**Application by National Highways for an Order
granting Development Consent for the Lower
Thames Crossing (Ref. No. TR010032)**

Deadline 4 – 19th September 2023

**Emergency Services & Safety Partners
Steering Group (ESSP SG):**

**Comments on the Applicant's
Submissions at Deadline 3
(REP3-078, REP3-111)**

# Mott Family Emergency Vehicle RVP Location

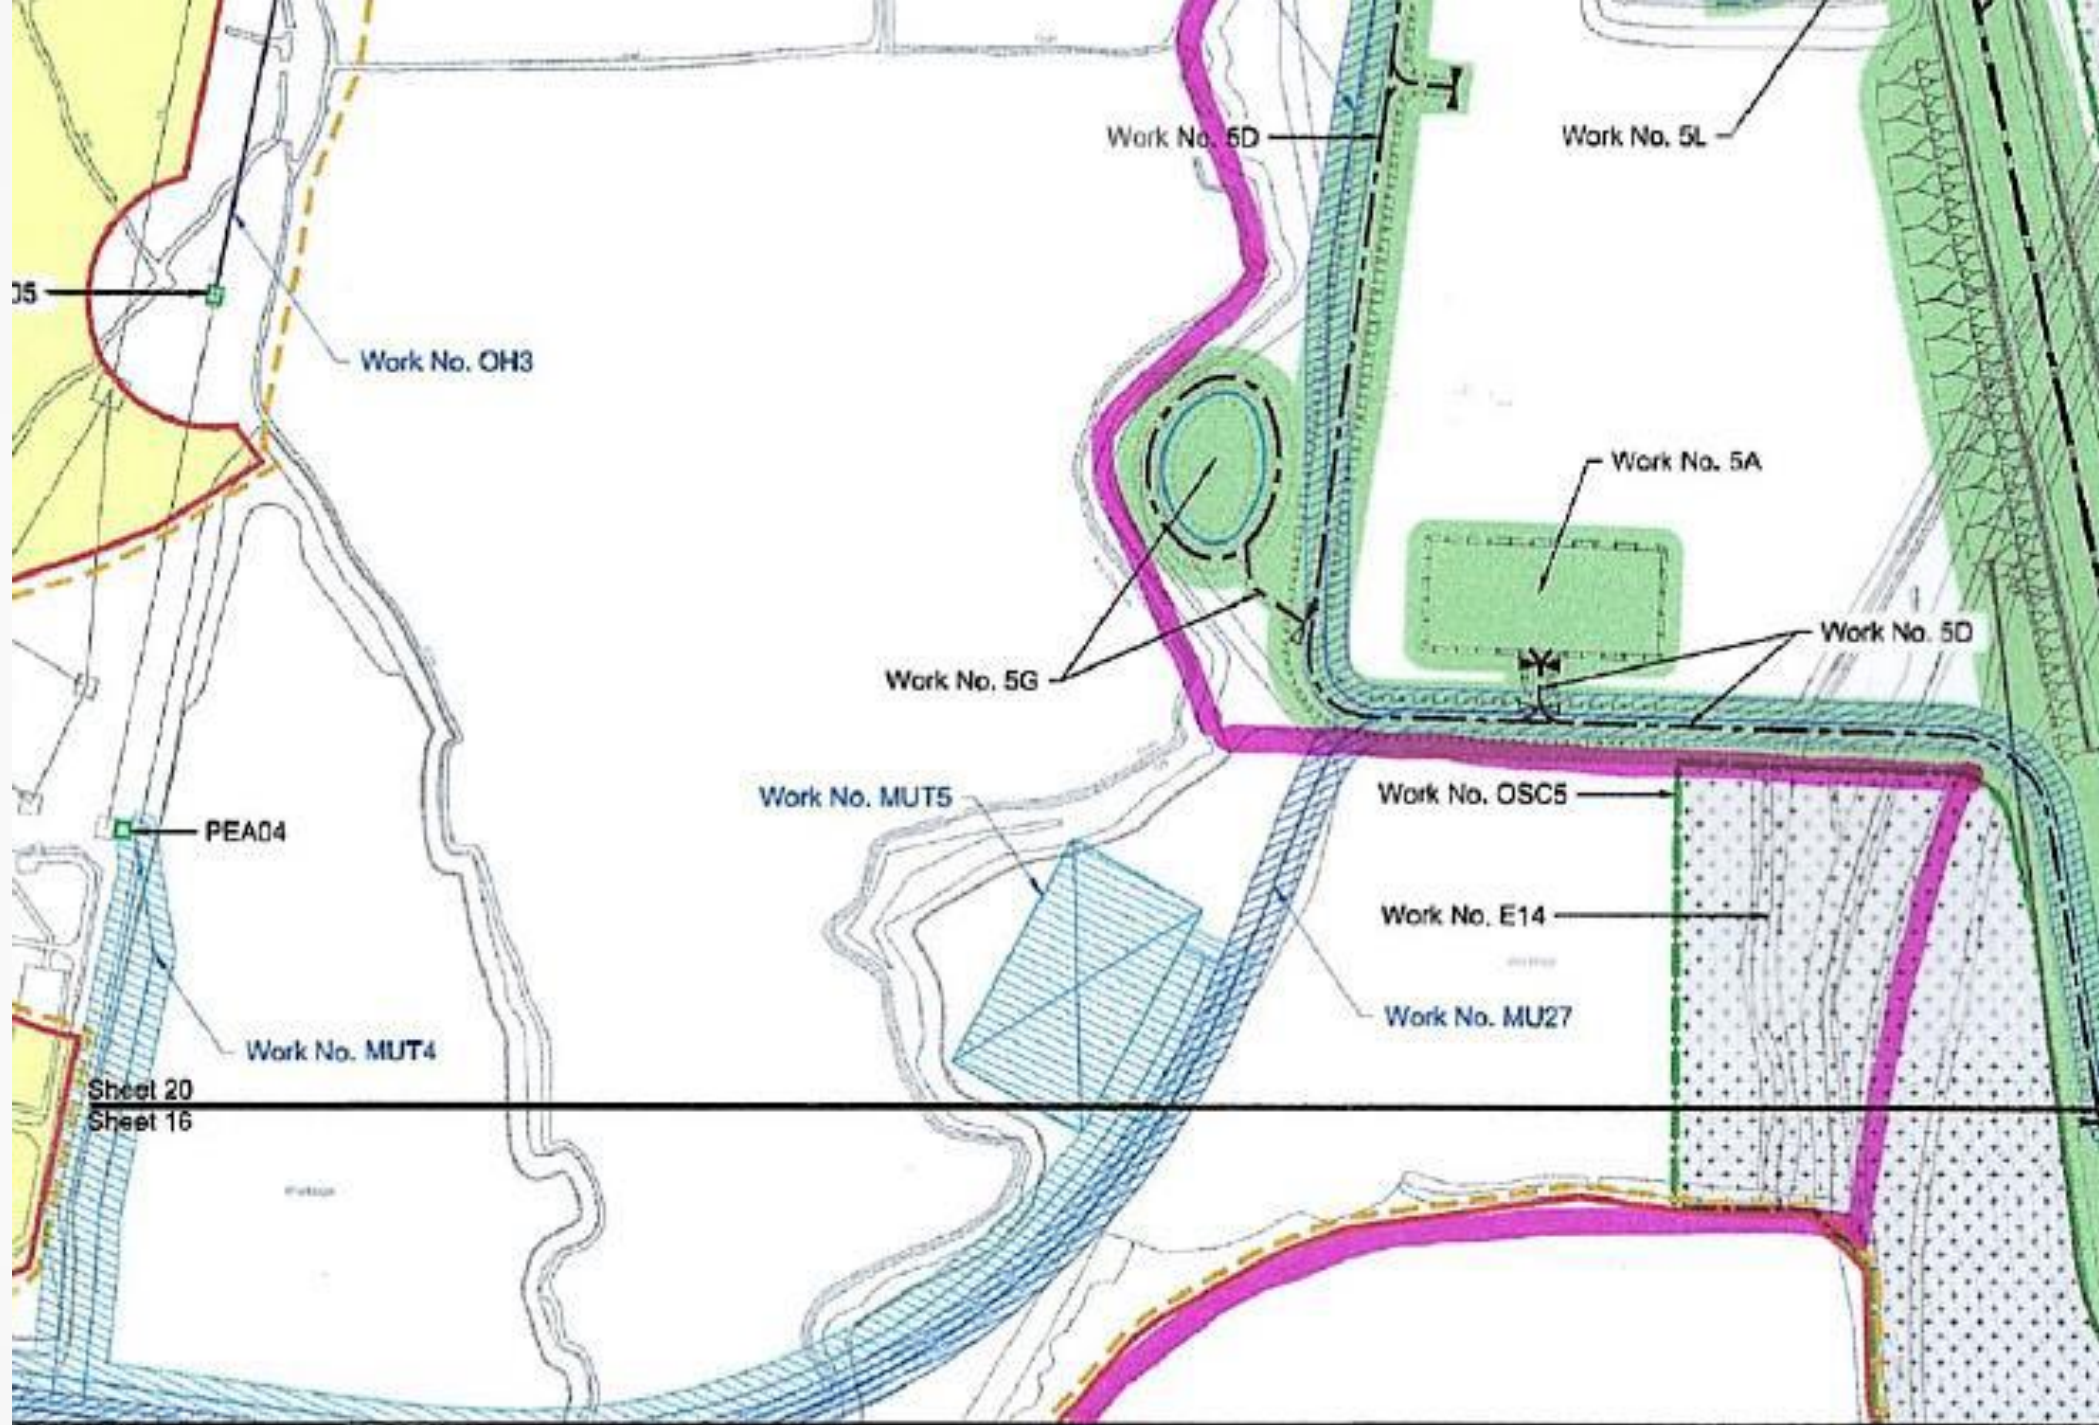
S3.20 and S9.21 - Emergency RendezVous Points (RVP)
5. The ESSP SG's concerns regarding the current RVP provisions for the project have been made clear to the ExA, for instance at paragraphs 26 - 29 of its Written Representation ([REP1-338](#)) and paragraph 10 of its Comments on the Applicant's Relevant Representations Report ([REP2-102](#)).
6. The ESSP SG has held a number of meetings with the Applicant, and continues to discuss the RVP provisions. If a greater level of agreement can be reached, this will be reported to the ExA and reflected in an updated version of the draft Statement of Common Ground submitted at Deadline 1 ([REP1-200](#)). It is very disappointing that the RVP proposals presented to the ESSP SG to date are considered inadequate.
